Consultation Response from KC, Conservation & Design
2022/92314 100, St John's Road, Birkby, Huddersfield, HD1 5EY
Erection of single and two storey side and single storey rear extensions to increase ground floor retail unit and HMO above (within a Conservation Area) (modified proposal)
Date Responded: 7.9.22
Responding Officer: Sue Brooks
Responding Ref:

client	MR CHAHAL		
project	100 ST JOHN'S ROAD BIRKBY HUDDERSFIELD HD1 5EY		
drawing	PROPOSED PLANS AND ELEVATIONS		
revision	notes	date	drawn
*	*	*	*
scale :	1:50 & 1:100 AT A1	07.22	PB
project no.	drawing no.	revision	
2210	02

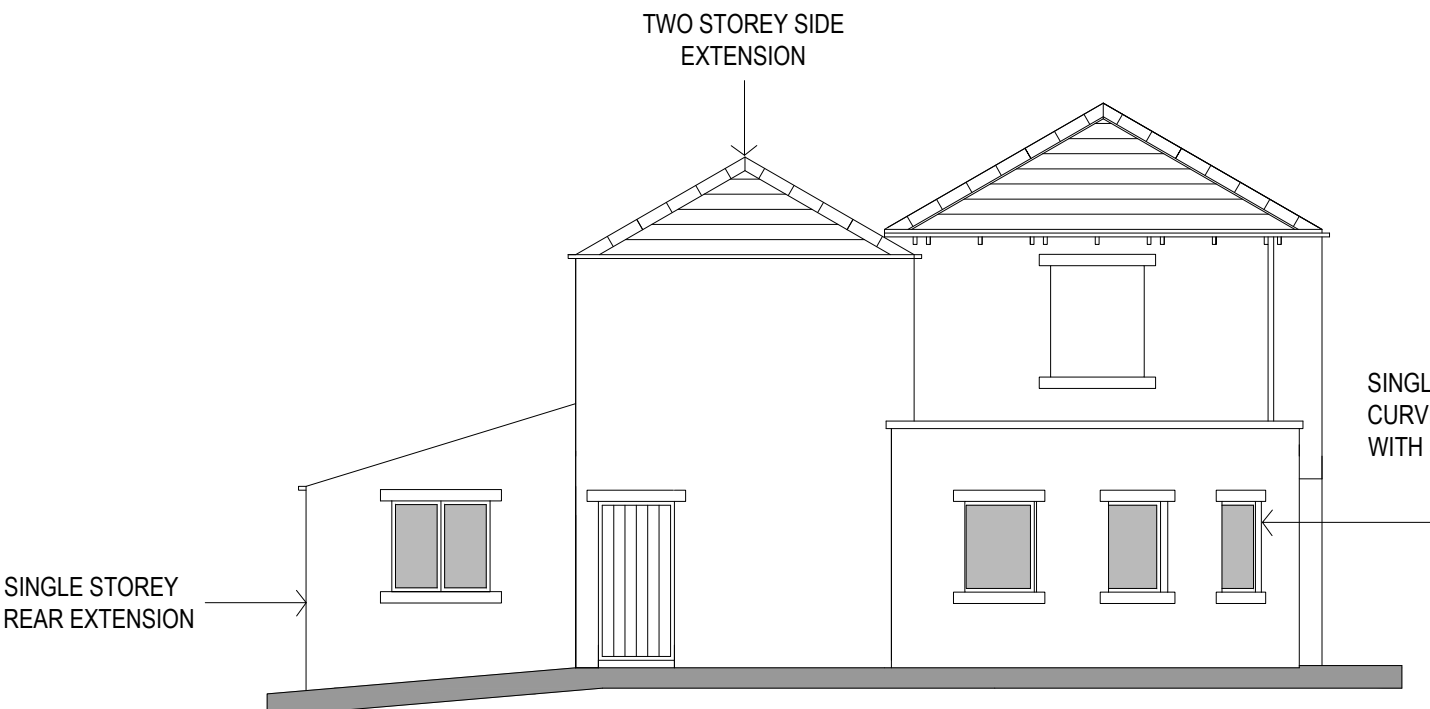
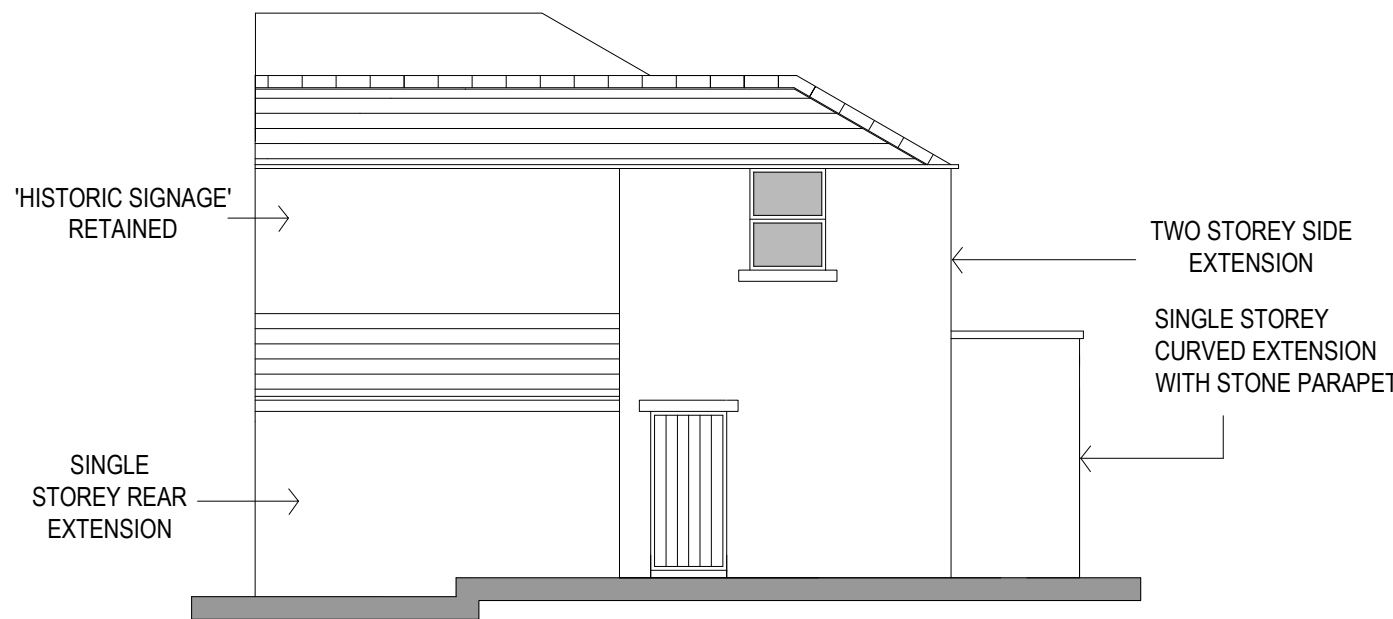
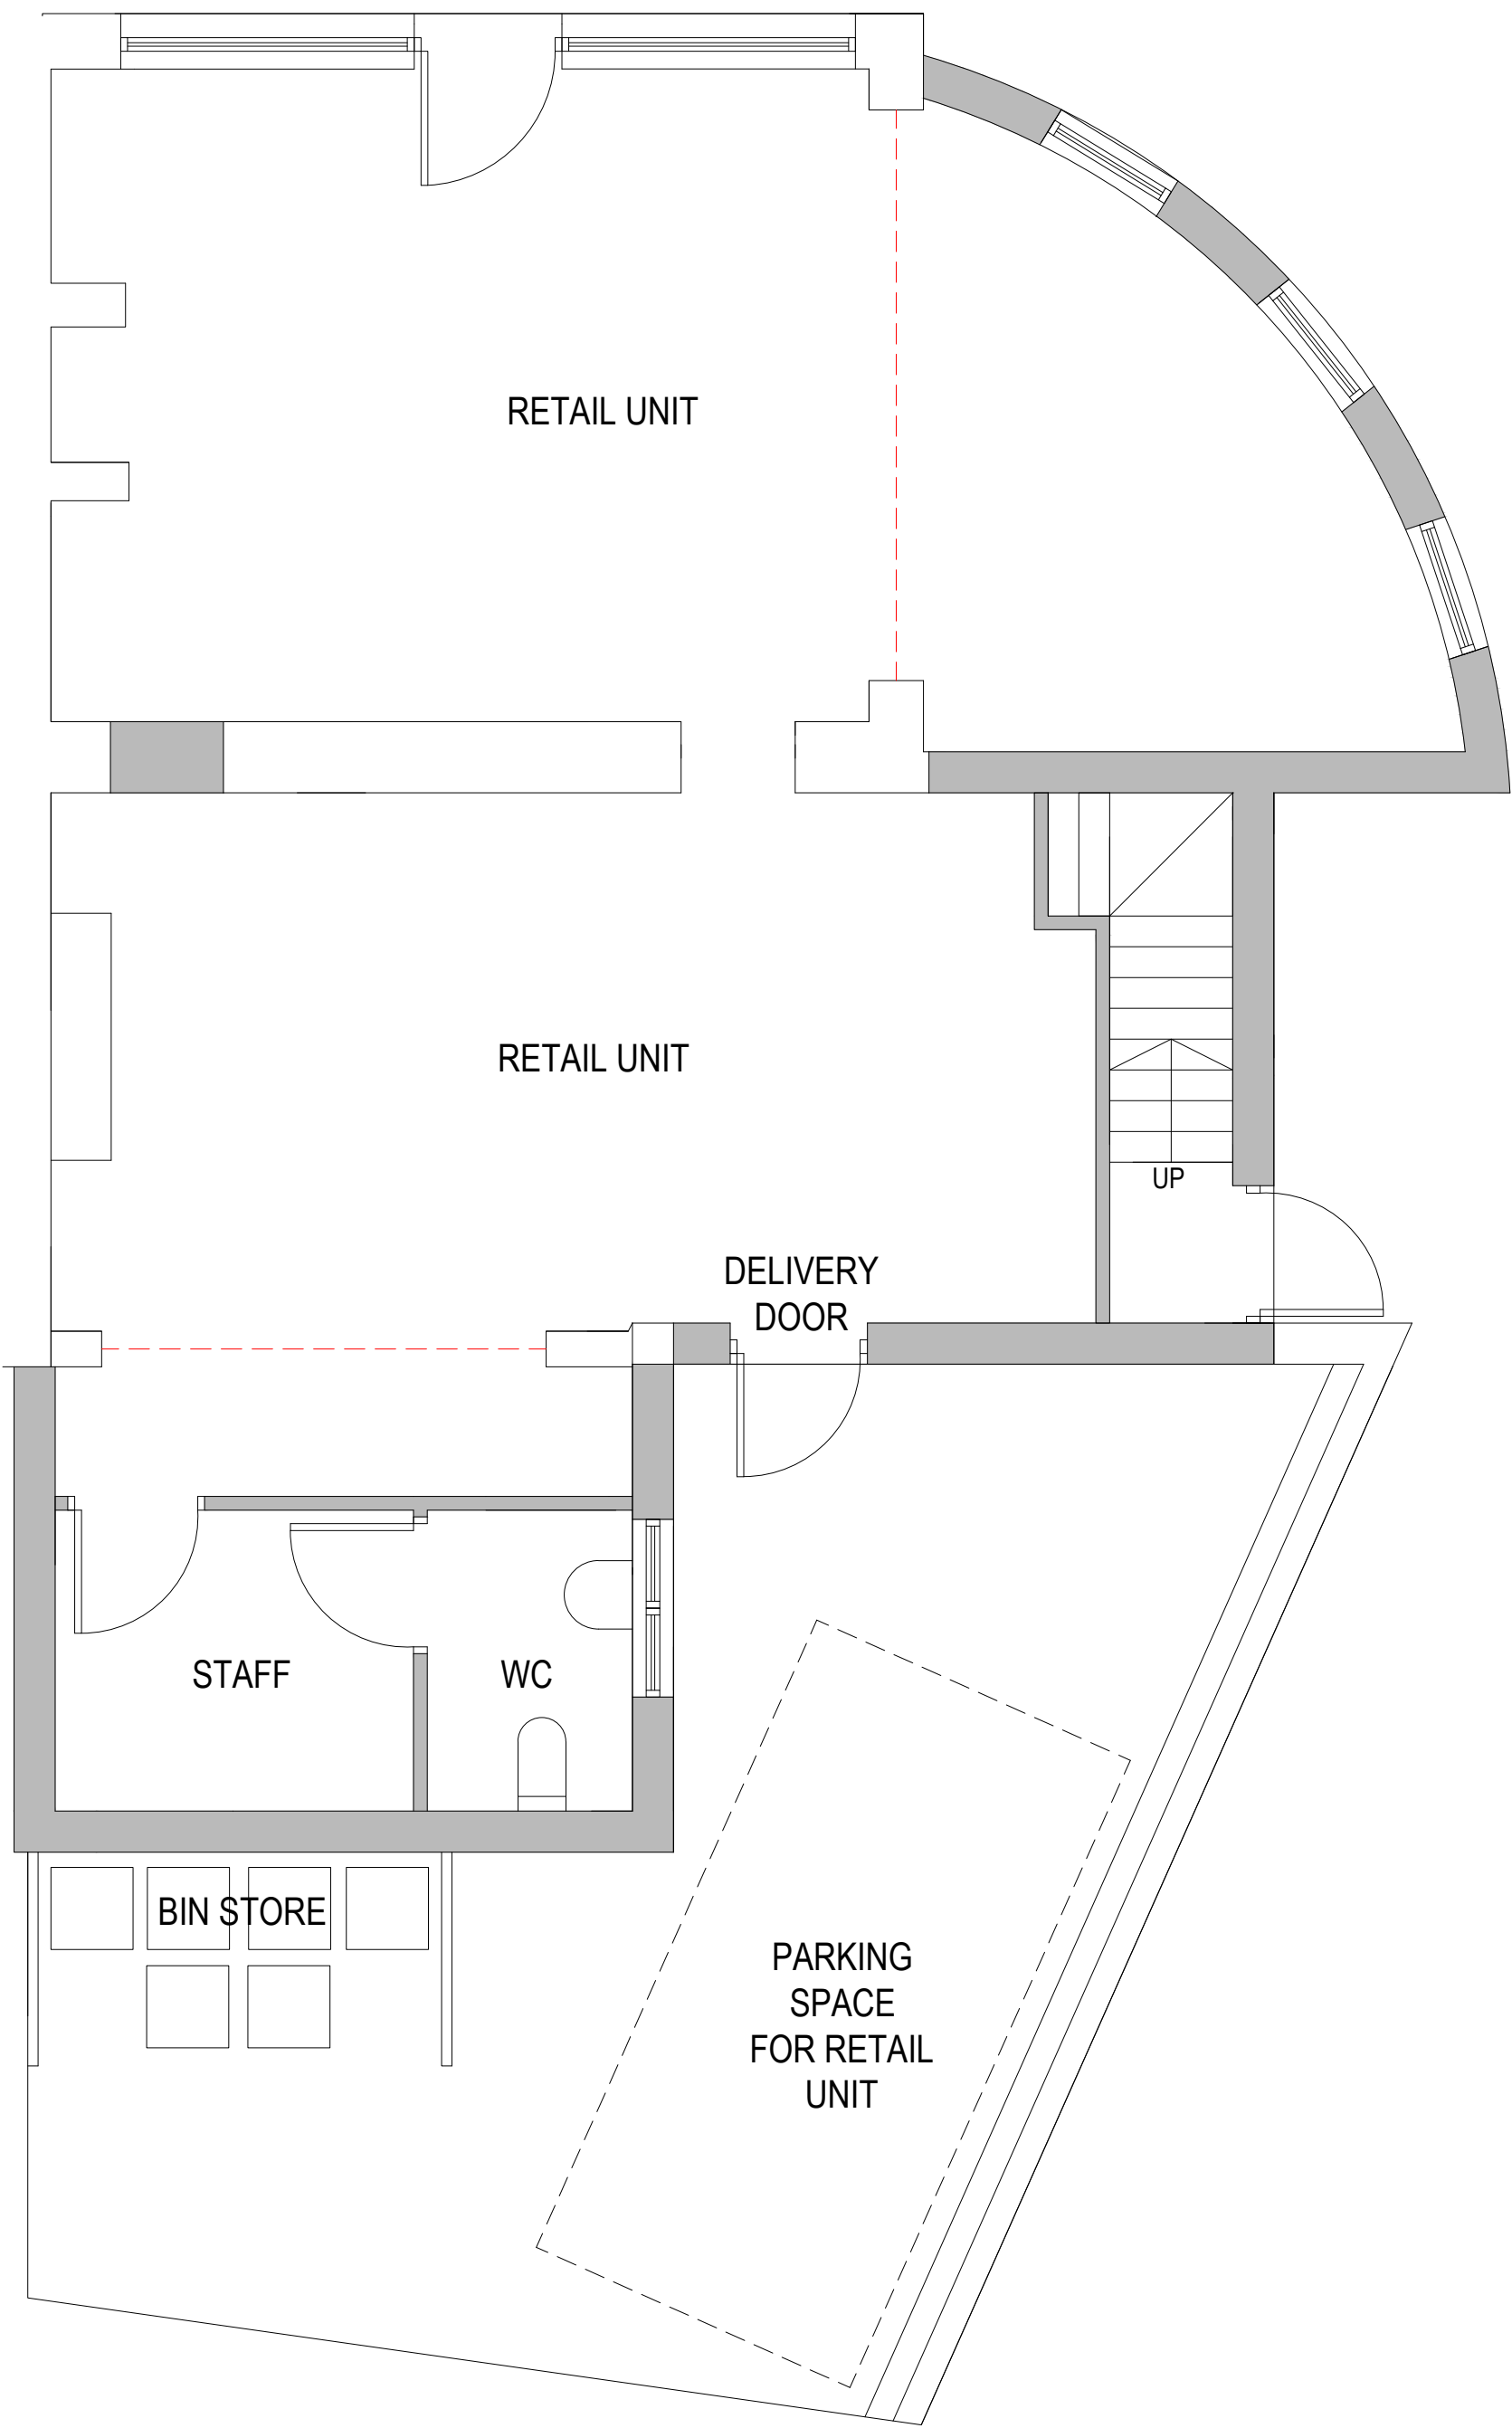
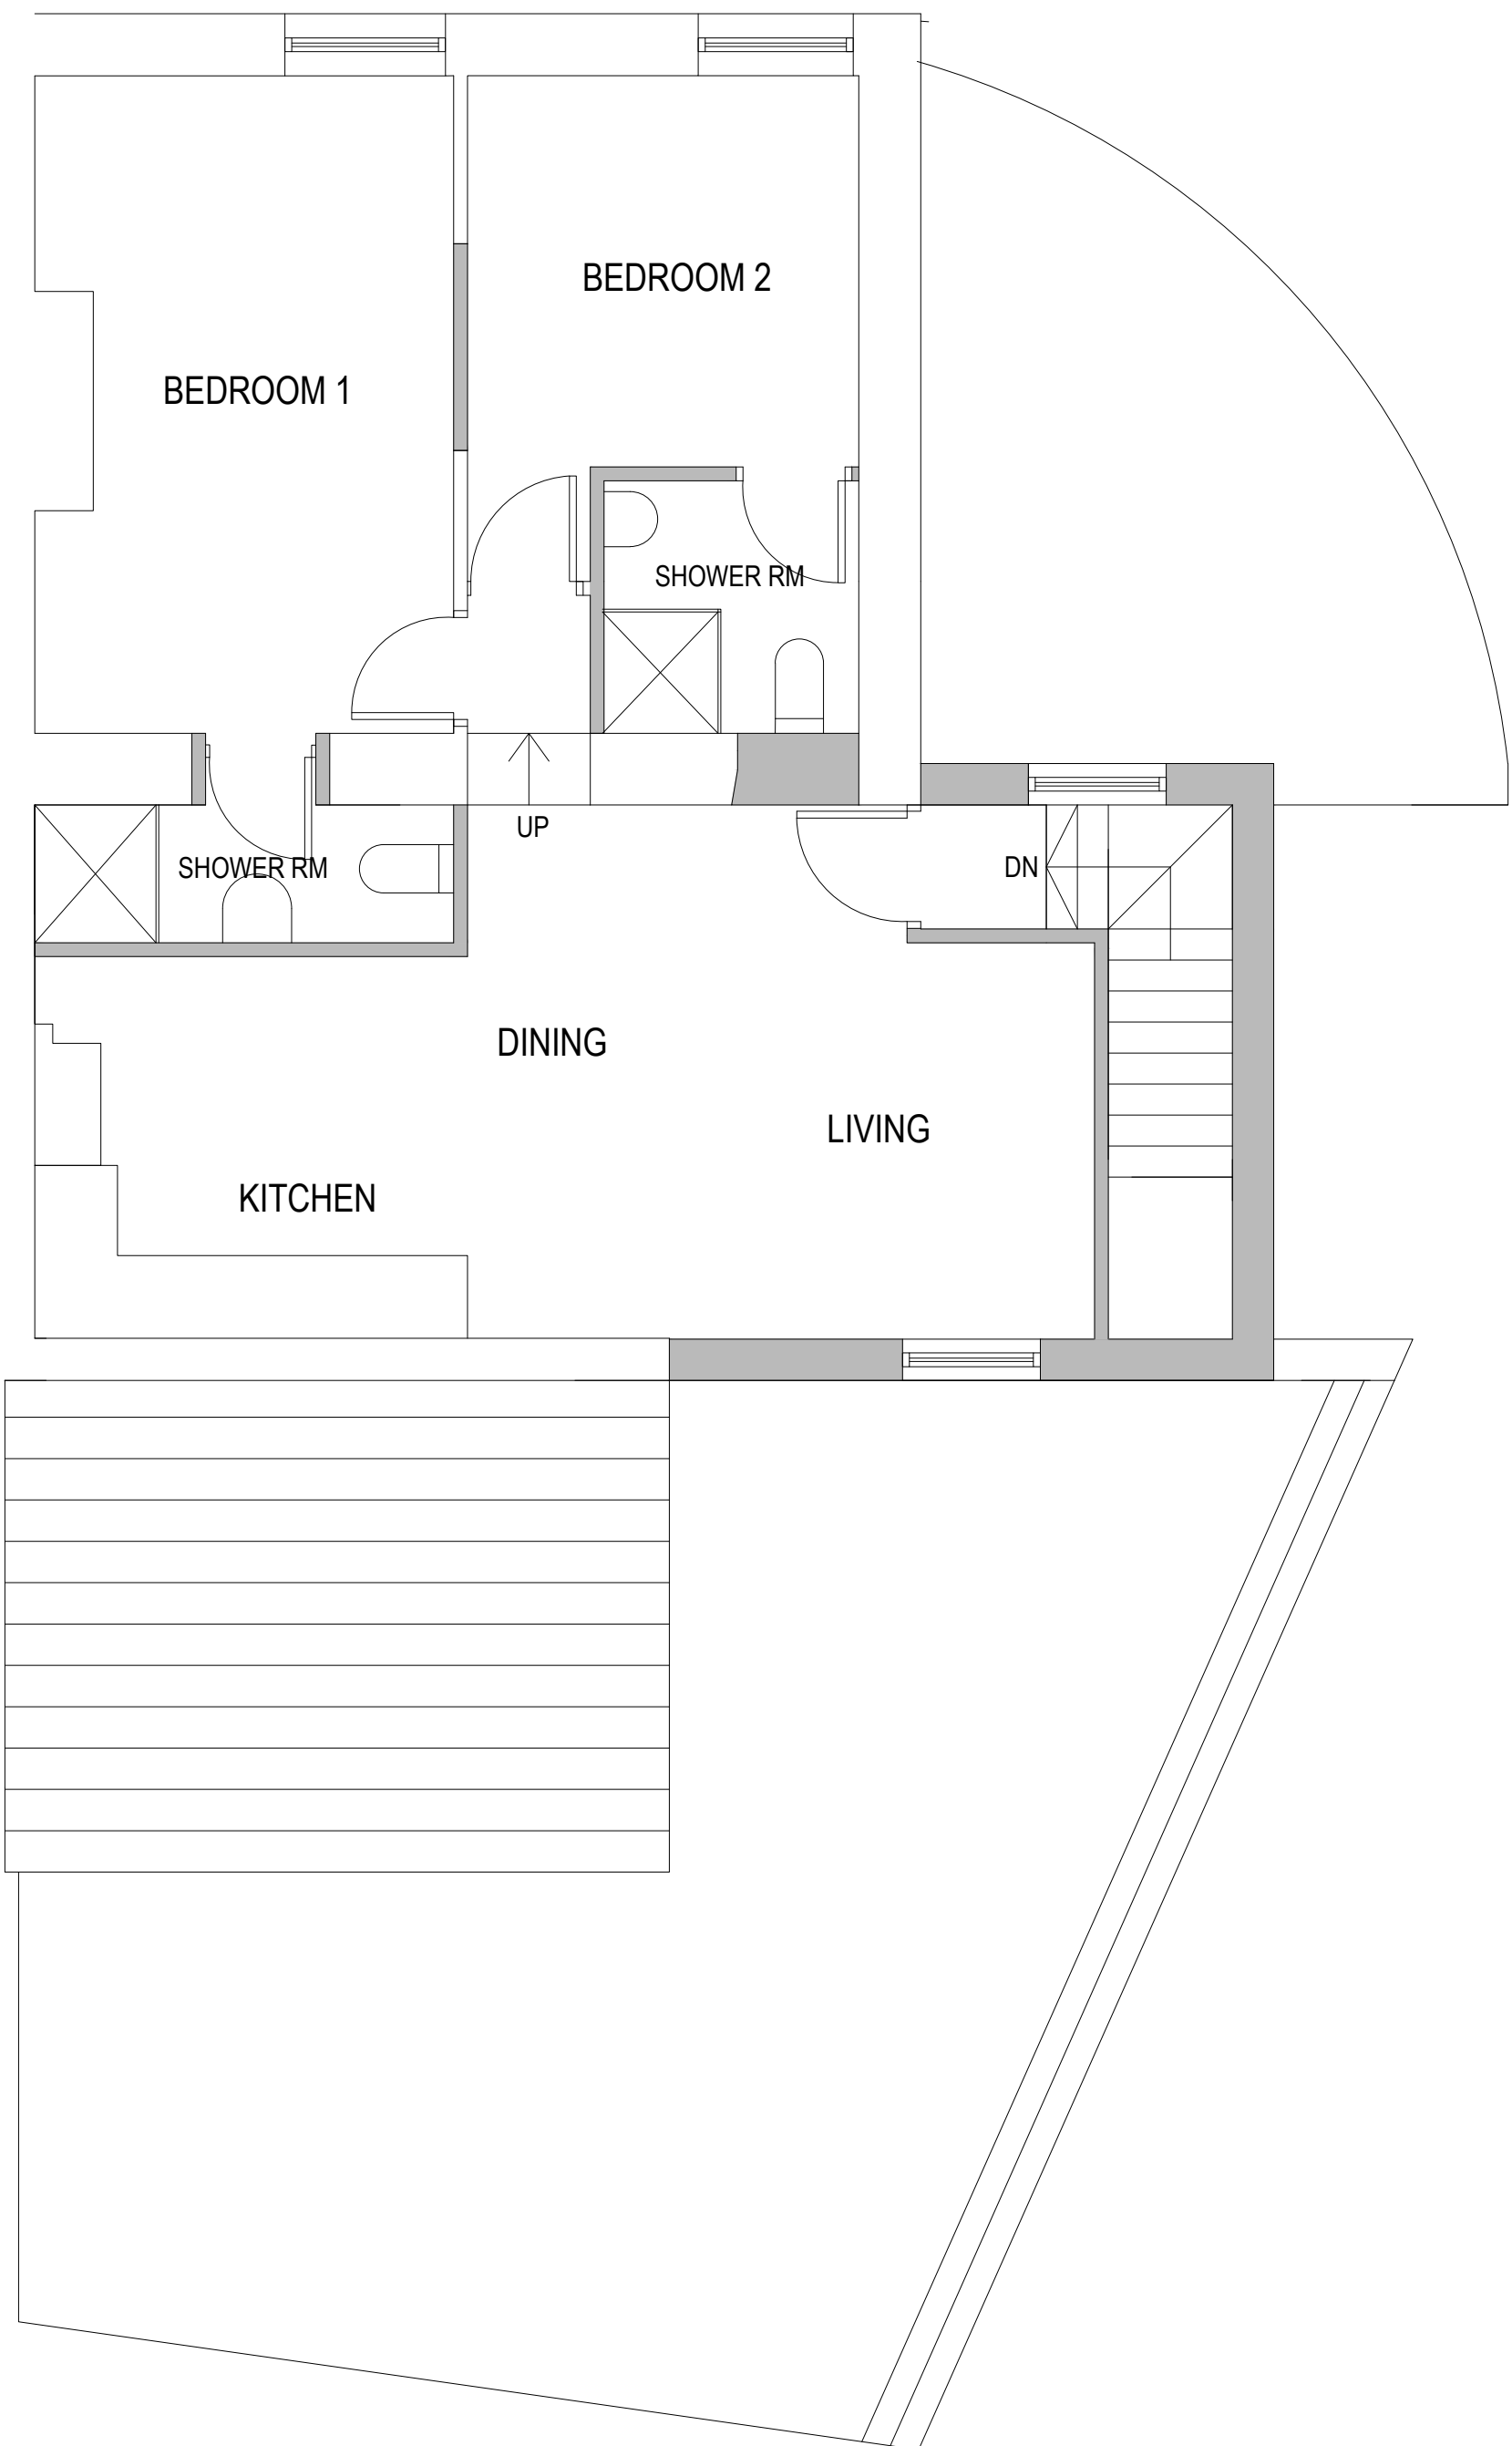
The current proposal has been amended following the previous application, with the rear extension reduced to single storey with a shallow mono-pitch roof to allow the historic slate cladding to be partially retained, and the two-storey side extension set back slightly from the boundary. The proposed materials are stone external walls, artificial blue slate roof, uPVC windows and timber steel plated doors.

As before, the amount of development on this site is substantial, with the proposed single storey flat-roofed side extension extending as far as the curved boundary of the site and beyond the historic building line of the terraced properties on Blacker Road to the rear. We would still consider this to be overdevelopment of the site in this key corner location and therefore we do not consider that the proposed development preserves and enhances the character of the conservation area. It does not meet the requirements of Policy LP35 of the Local Plan and is contrary to Policy 72 of the Planning (Listed Building and Conservation Areas) Act.

The Conservation and Design Team is unable to support this proposal.
